REPORT UPDATE

Application No: BR/141/18/PL

LOCATION: 26 Nyewood Lane
Bognor Regis
PO21 2QB

PROPOSAL: Change of use from dwelling (C3 Dwelling House) to 8 bed HMO (Sui Generis).

New layout

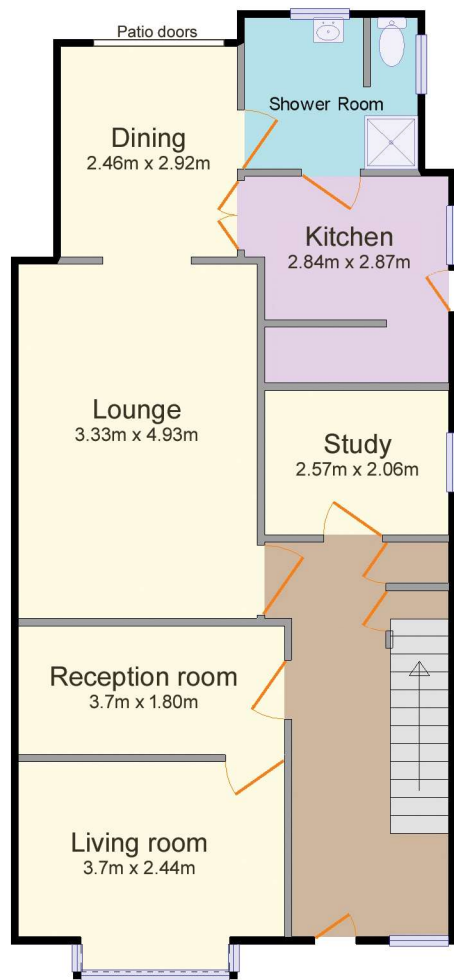
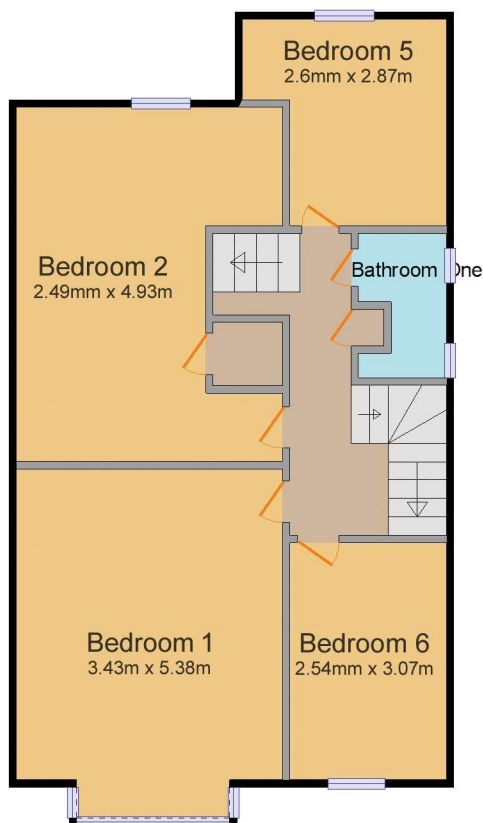
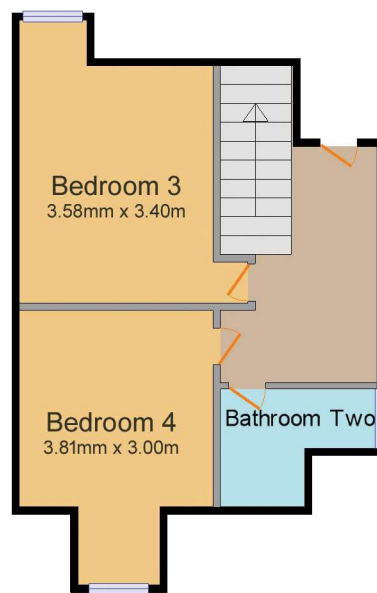
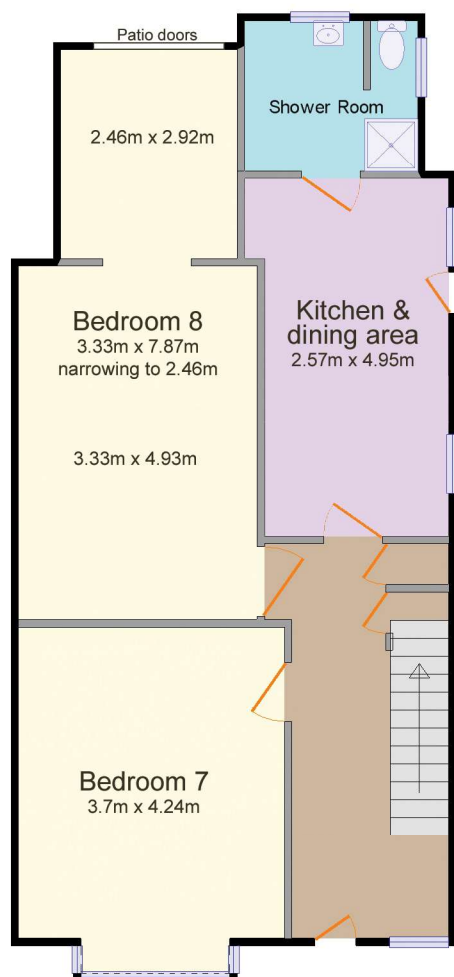
- (1) Over development - severe overcrowding & tiny bedrooms;
- (2) Ground floor shower & WC is accessed via the kitchen - not healthy in respect of food preparation;

- (3) Only one very small bathroom shared between four bedrooms;
- (4) Limited private amenity space;
- (5) Inadequate cycle stores;
- (6) Out of Character with surrounding area;

There are no new windows proposed and the only changes in room type are to the ground floor with a front living room becoming a bedroom and a rear dining room becoming additional space to a large bedroom. As such, the only new overlooking impacts that will occur will be those that are screened out by existing boundary treatments.

- (1) Overdevelopment and room sizes will be considered in the conclusions section of the report;
- (2) This is not an uncommon layout and if it were a problem then the Council could choose not to grant a HMO Licence (this being a separate process to the planning application);

- (3) Room sizes will be considered in the conclusions section of the report. Furthermore, if this were a problem then the Council could choose not to grant a HMO Licence;

In the case of this application, nos. (1) & (3) would apply i.e. 6.5m² for a single bedroom and 10m² for a double bedroom. All of the rooms comply with the smallest bedroom, 7.5m² and the largest 18.5m².
